Subject: AL/67/25/PL Nyton Rest

I had intended to issue this under delegated powers by the 6th of January. However, we received a Parish objection on the 12th and so we will have to take this to our planning committee. The next one is 14 January, but reports must be written by end of Monday 22/12, and I am already up against it trying to get a report done for then. So, I'm afraid, this will therefore have to go to the February Meeting (18/02) instead. I will be recommending approval. I would be grateful if you can agree Extension of Time until 20/02/25. It would also be helpful if you could provide a response to the Parish comments, as set out below:

The parish council objects to this application on the following basis. This site is currently allowed on a temporary basis and the parish council believe that before a decision is made to make it permanent then the following needs to be addressed:-

Drawing Title	Surface Water Flood Risk Flood Maps for Planning
---------------	---

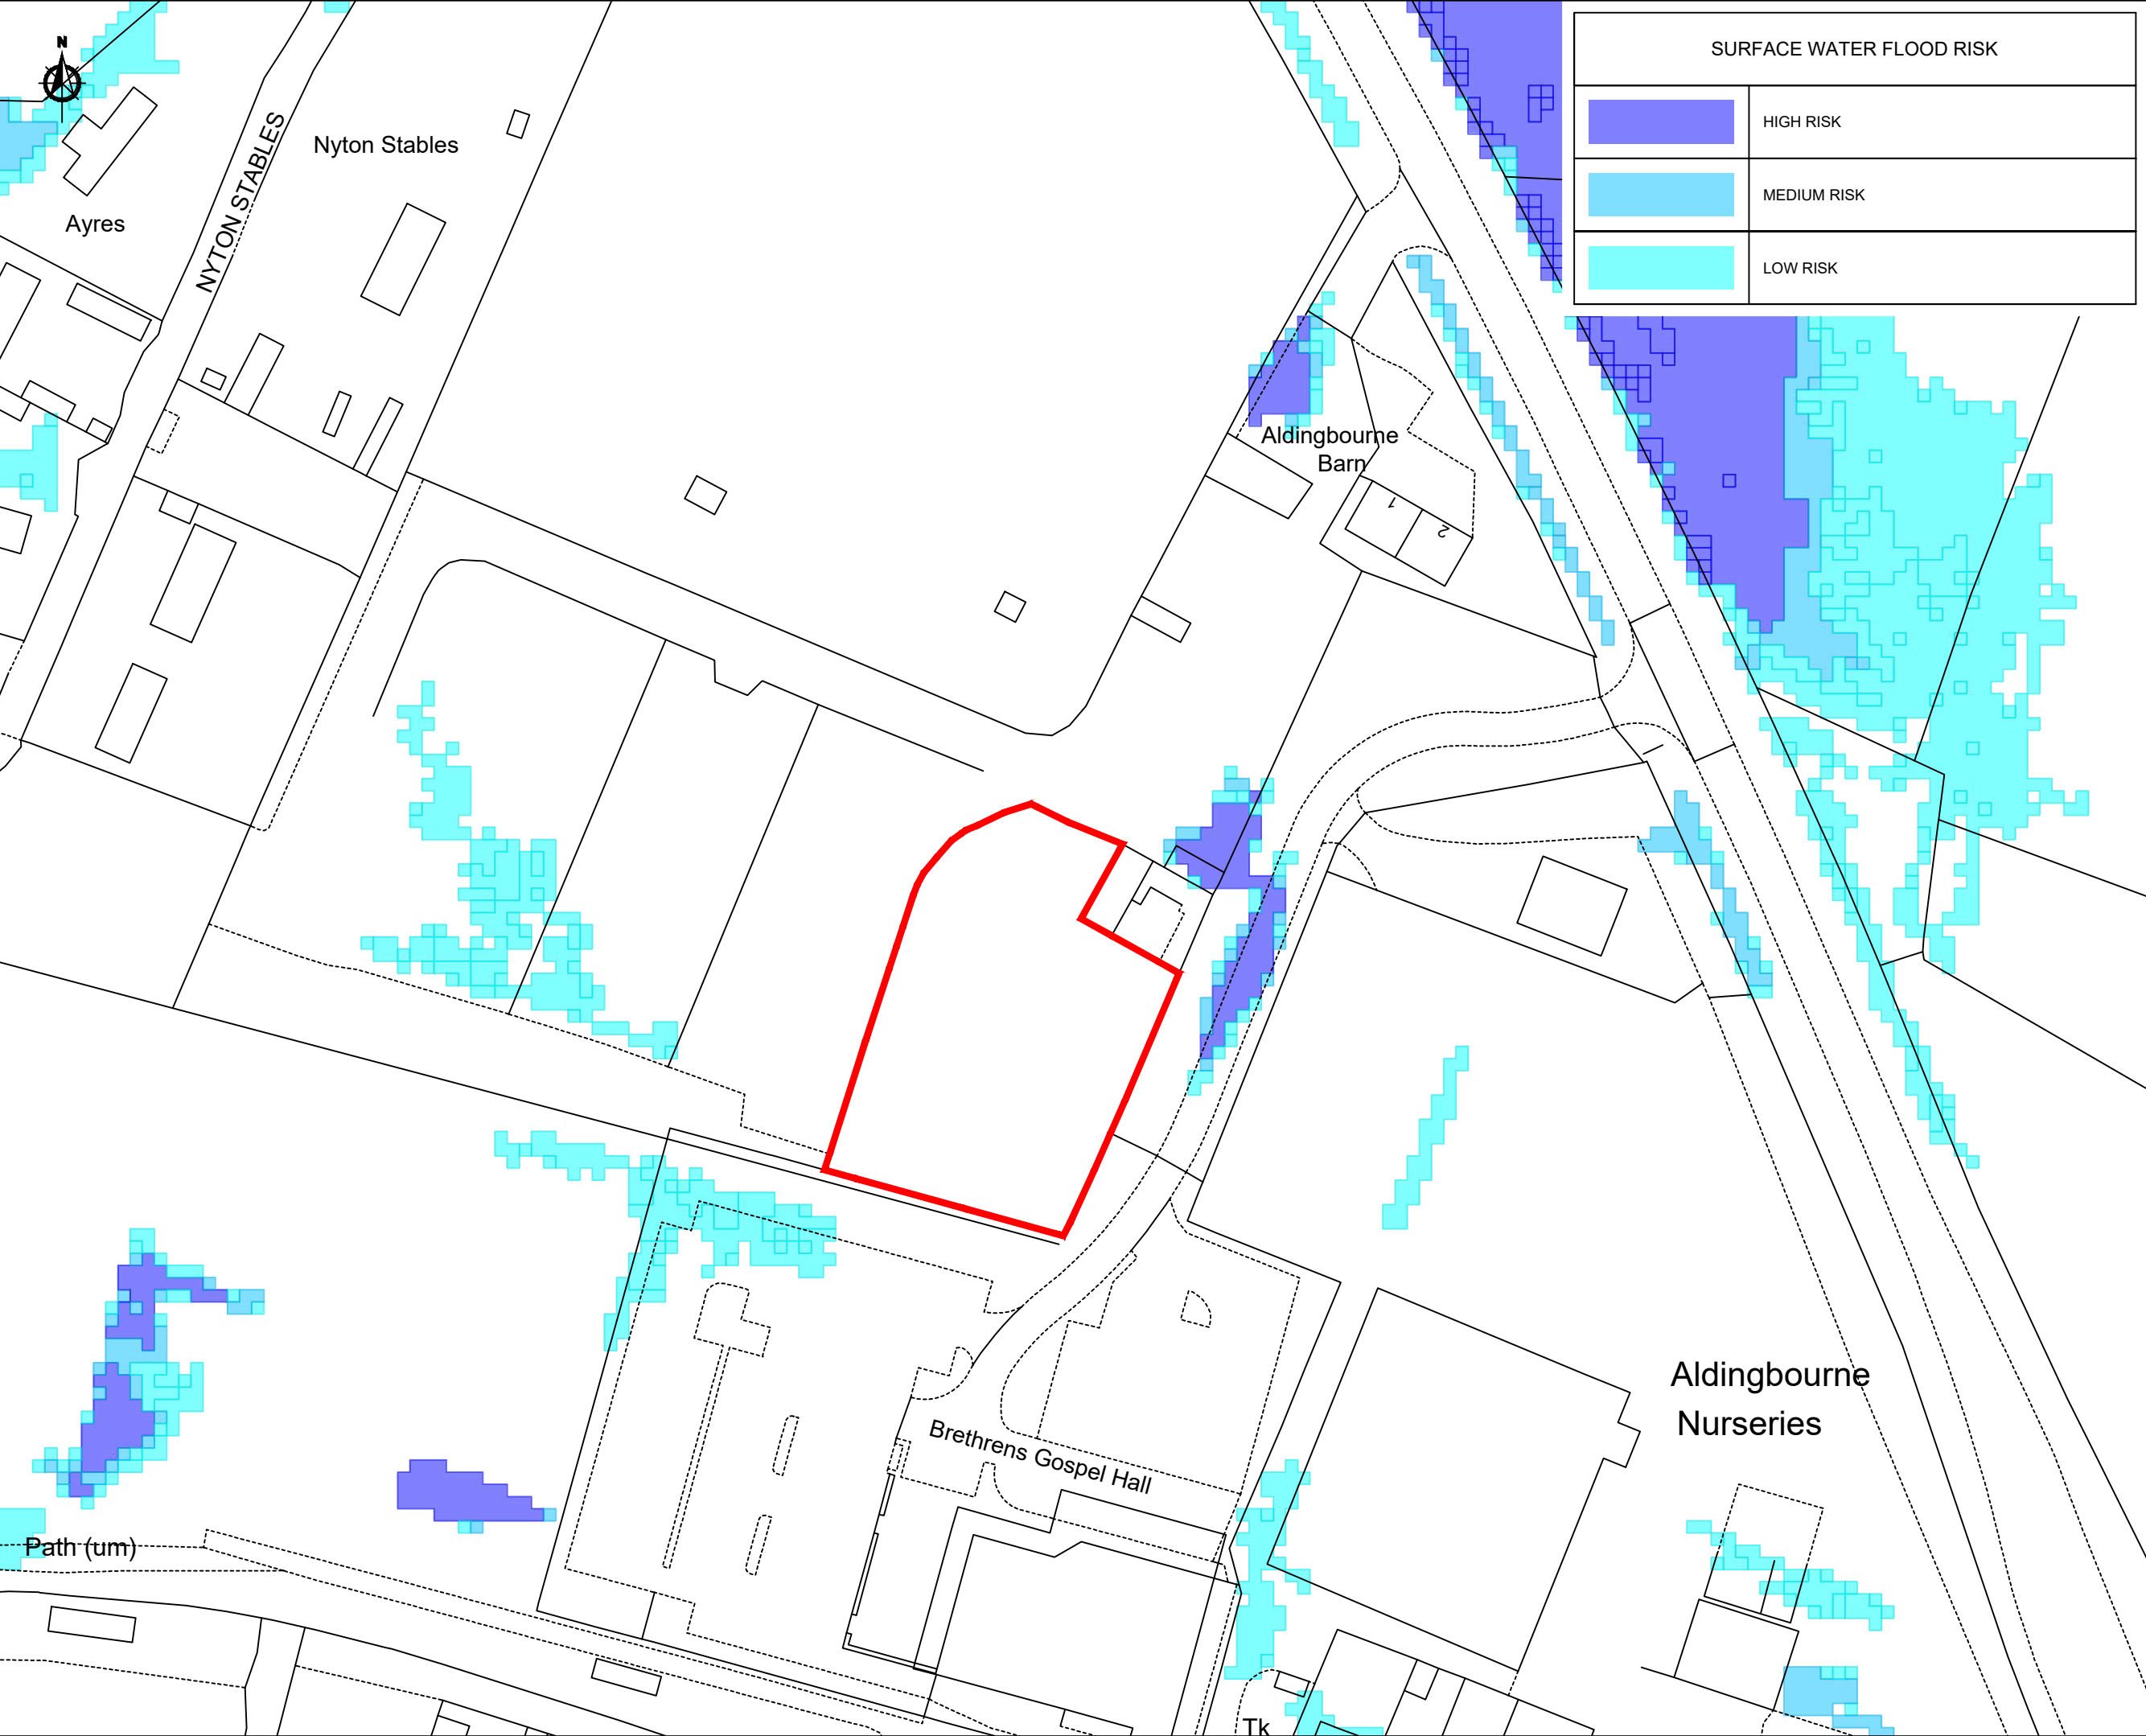
9.1, however the parish council has concerns as there is extensive flooding in the parish at the moment and this report says the site has a permeable surface which is free-draining. Should extreme rainfall events occur which exceed the ground's capacity to drain efficiently, surface water flooding may occur. Given the flat nature of the site, this would likely result in localised ponding on site and although the site is identified as being at Very Low risk of surface water flooding groundwater investigation and monitoring has not been undertaken at the site. As such, groundwater levels on site are unknown. The parish council believes that this should be investigated further to identify the correct risk of flooding on the site and to ensure the drainage is fit for purpose.
